## 2 Darcy Road Westmead

### EIS Peer Review

A State Significant Development application (SSD-10352) for the redevelopment of 2 Darcy Road in the City of Parramatta LGA is currently being assessed by the Department of Planning, Industry and Environment (the Department). The SSD proposal covers only the first stage of the redevelopment. Future stages of the development will be subject to separate planning approvals. The SSD application seeks approval for:

Project:  
P4803

Figure 5 SIDRA modelling points

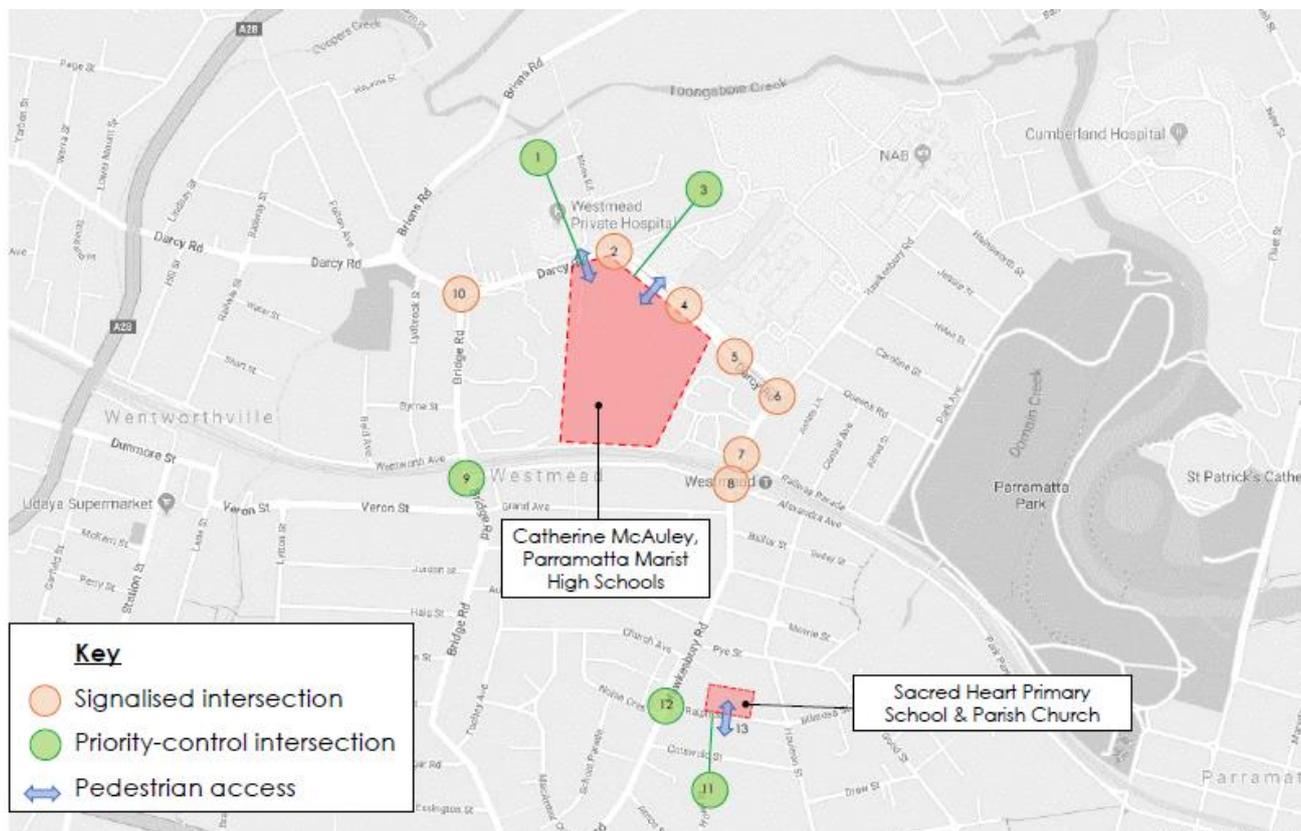
Item	Section/Page	Bitzios Comments	Priority	Comments on the Ethos Urban responses	Required Action
40	General Comments	<ul style="list-style-type: none"> <li>▪ SCATS history data was not collated from TfSNW SCATS data and the corresponding '.LX' file containing traffic signal cycle time, phase time, phase sequence and signal co-ordination information including offsets does not appear to have been used. These should be provided so that we can verify the signal timings.</li> <li>▪ It is an industry wide practice to use SCATS history data to develop, calibrate and validate SIDRA models. No credible phase or cycle time data was available to compare with the SIDRA models.</li> <li>▪ No information was provided on the average observed queue lengths.</li> <li>▪ The base models have some issues with the model network settings and parameters which will impact key modelling results. One example is the use of inaccurate approach distances which will impact the network analysis.</li> </ul>	High	Adequately discussed. However, cannot be confirmed as the updated Sidra Models and revised calibration validation report were not made available.	Not resolved

41	General Comments	A quick comparison of some base and future models shows changes in volumes only. However, intersection layout and traffic signal settings (e.g. inclusion of PLR) do not appear to change.	High	Adequately discussed	No
42	Signal Coordination	Co-ordination was applied at signalised sites 8, 6, and 4. However, with 'offset' set as 0 second. It was not possible to verify the offset as no '.LX' file data was available. However, it is highly unlikely that offsets are set as 0 seconds in this corridor.	High	The proponent tried to resolve the issue with the video footage but unfortunately this does not verify the detailed SCATS signal data information that is required.	Not resolved
43	Modelling Settings	The resulting SIDRA phase times vary substantially with the observed phase times. This is due to the selection of 'user given cycle time' option in the traffic signal settings. The use of this setting will enable SIDRA to maintain the cycle time. However, SIDRA will optimise the phase time. The resulting phase times are often very different from the observed phase times. This explains the substantial differences as reported in the technical note between the observed and modelled phase times.	High	Adequately discussed and updated in the revised Sidra Models. However, cannot be confirmed as the updated Sidra Models were not made available.	Not resolved
